Kirklees Metropolitan Borough Council -
Planning Services
HUDDERSFIELD, HD1 2JR

Reference: PA-0004535/01
Customer reference: 2026/62/90823/E
04 June 2026

**Demolition of existing workshop and erection of larger workshop at Wakefield Road
Denby Dale Huddersfield HD8 8RP**

Environment Agency Position

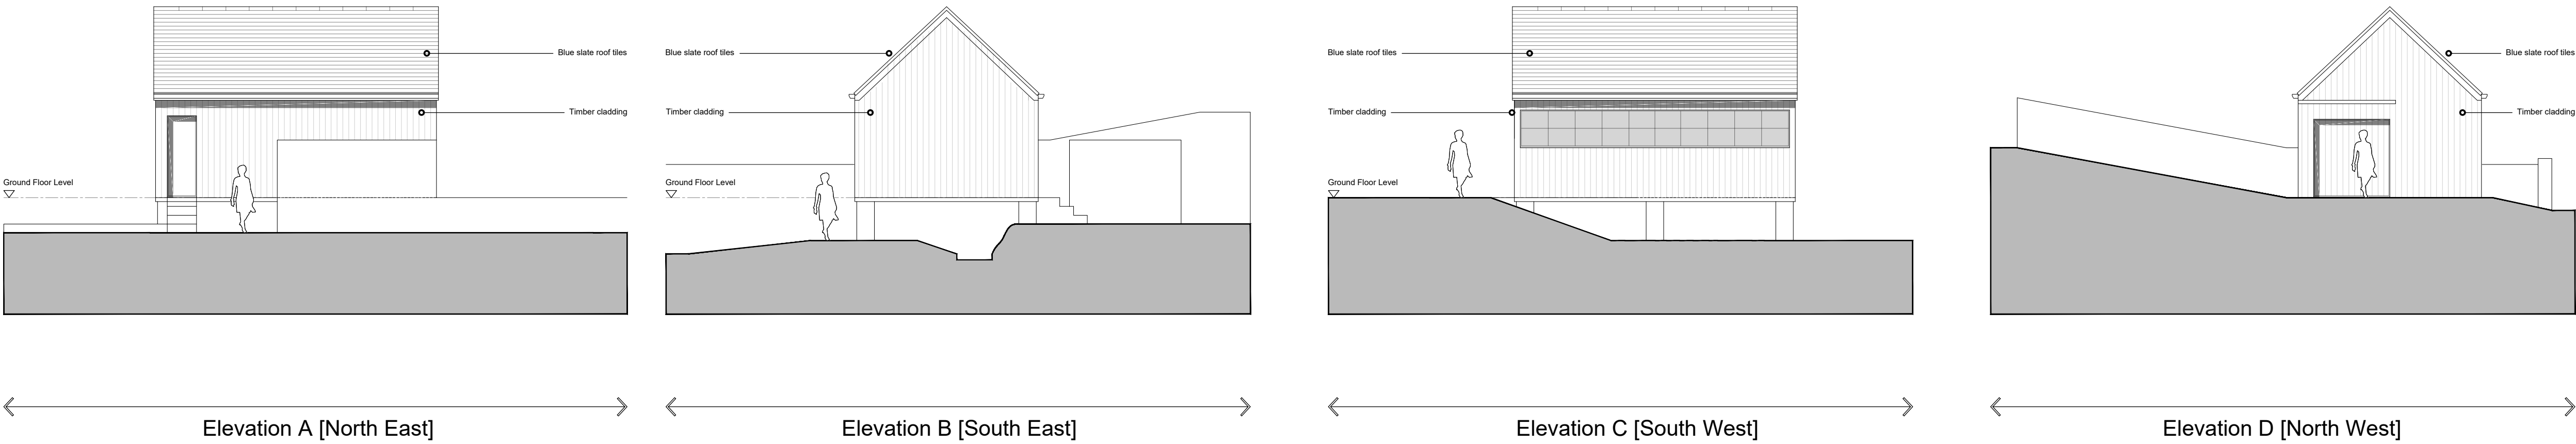
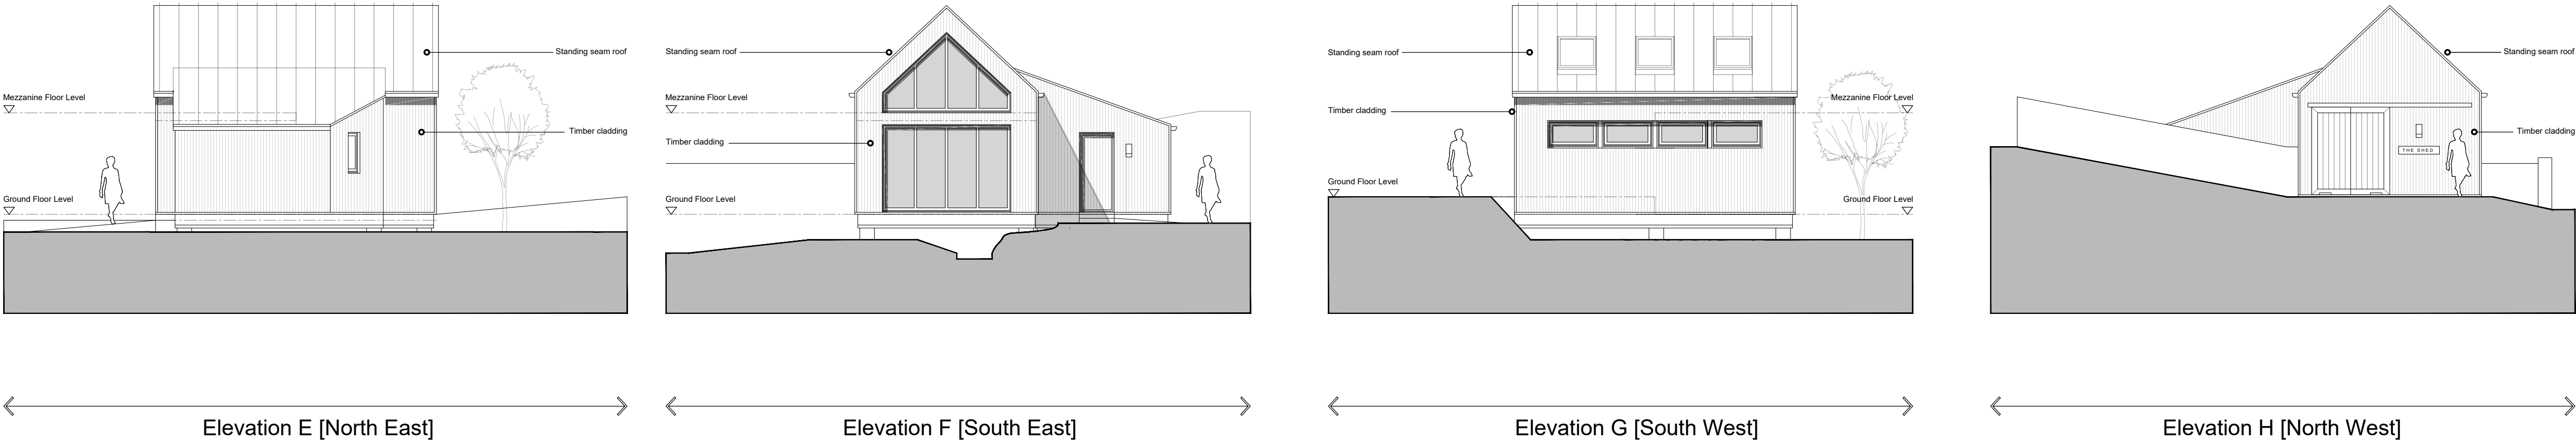
- demonstrate that the development does not increase flood risk to others.
 - We note the proposed development is replacing the existing building which appears to be on stilts over the watercourses with the proposed new building also being on stilts over the watercourses. The soffit of the new building appears to be significantly lower than the existing building. The FRA will need to be updated to demonstrate that the soffit of the proposed development is suitably above the design flood level, and will not increase flood risk, including in event of a blockage.
 - This should include consideration of the impact of loss of floodplain storage and demonstration that offsite land and property will not experience increased risk. If increased risk is predicted, then appropriate mitigation measures will need to be demonstrated.

We are opposed to the culverting of any watercourse because of the adverse ecological, flood risk, geomorphological, human safety and aesthetic impacts. We note that the proposed development involves replacing an existing building that is sited above 2 ordinary watercourses with a new building over the watercourses. We have not objected to the principle of the proposed development on this basis but wish to note that this is a missed opportunity to de-culvert these watercourses. In demonstrating the proposed development will not increase risk to others, the applicant should be mindful of Paragraph 049 of the Planning Practice Guidance which states "Whilst the use of stilts and voids below buildings may be an appropriate approach to mitigating flood risk to the buildings themselves, such techniques should not normally be relied upon for compensating for any loss of floodplain storage. This is because voids do not allow water to freely flow through them, trash screens get blocked, voids get silted up, they have limited capacity, and it is difficult to stop them being used for storing belongings or other materials.". Any compensatory storage should be provided on a like for like, level for level basis.

To overcome our objection, the applicant should submit a revised FRA which addresses the points highlighted above. If this cannot be achieved, we are likely to maintain our objection. Please re-consult us on any revised FRA submitted and we'll respond within 21 days of receiving it.
